Consultation Response from KC Landscape	
Application No:	2025/91531
Proposed Development:	Demolition of pair of semi-detached houses and construction of 51 dwellings
Location:	Land off Leeds Road, Heckmondwike
Applicant/Agent:	Orion Homes Ltd
Planning Officer	Jillian Rann
Date Responded:	19.08.2025
Responding Officer:	Landscape
Responding Ref:	PP33

Figure 2.1
Proposed Site Layout

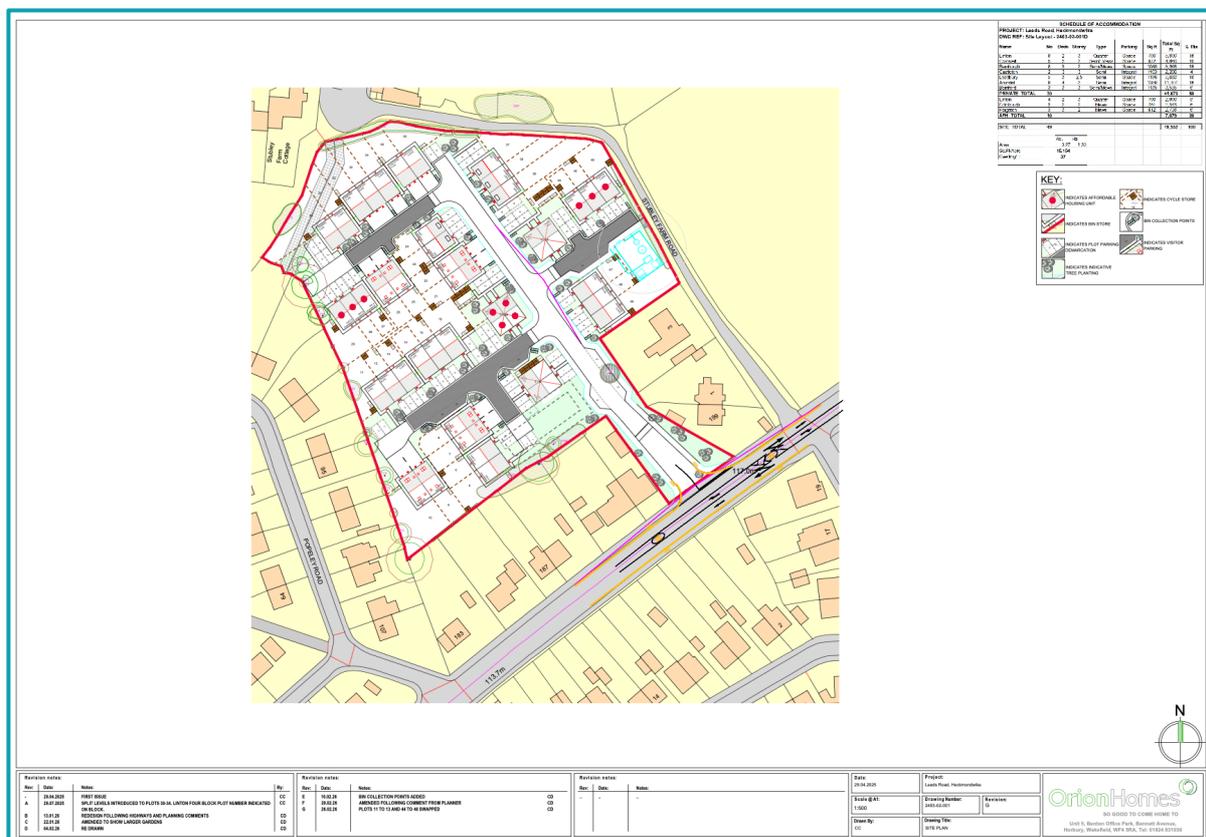
4. The proposed landscape layout drawing is sparse in terms of green structure, landscape proposal does not provide significant improvement to scheme or offer the existing landscape and setting strong enhancement. There is an opportunity to improve existing green structure providing robust mitigation and additional habitat.

5. The plan is very indicative in landscape terms, therefore difficult to provide meaningful comments, however, some green areas are shown on site is shown and is welcome, however, consider access and purpose of the spaces being created.

6. Will the grassed space provided adjacent to the pumping station be a public open space and if so, how will it be designed and laid out to meet the needs of the widest possible range of users, be easily accessible and enjoyed by all people, regardless of visual, physical and cognitive ability, mobility, background or age, especially if they are just grass over an attenuation tank?

7. The entrance area looks more likely highways verge and entrance planting to meet the needs of BNG rather than public open space.
8. Green spaces should be "high-quality," and ensure that the green space is substantial enough to accommodate a variety of recreational activities, making it an inviting hub for people to spend time in.

10. Access to the POS should not be from private drives and is there really no pavement at all next to the green space? The whole scheme seems to have an excessive number of turning heads and private drives. Dead ends and turning heads necessitate increased reversing manoeuvres for all vehicles including resident's cars and vans, delivery vans, lorries and refuse vehicles. Reversing manoeuvres are a risk to H&S for pedestrians and youngsters especially with no pavements or for those accessing green spaces. The numerous dead ends and turning heads should be designed out as far as practicable.

18. The tokenistic trees indicated on the plan are inadequate.
19. Details should be submitted for proposed tree planting in front gardens and highways verges demonstrating adequate soil volumes and tree pit details to support the growth of the tree for the long term, such as: the volume of tree pits, details of soil volume & root management, details of installation, timing/planting season and long term management.

demonstrate habitat areas, planting native species, and creating ecological corridors to facilitate the movement of wildlife. Landscape scheme seems a bit limited on attenuation tank area.
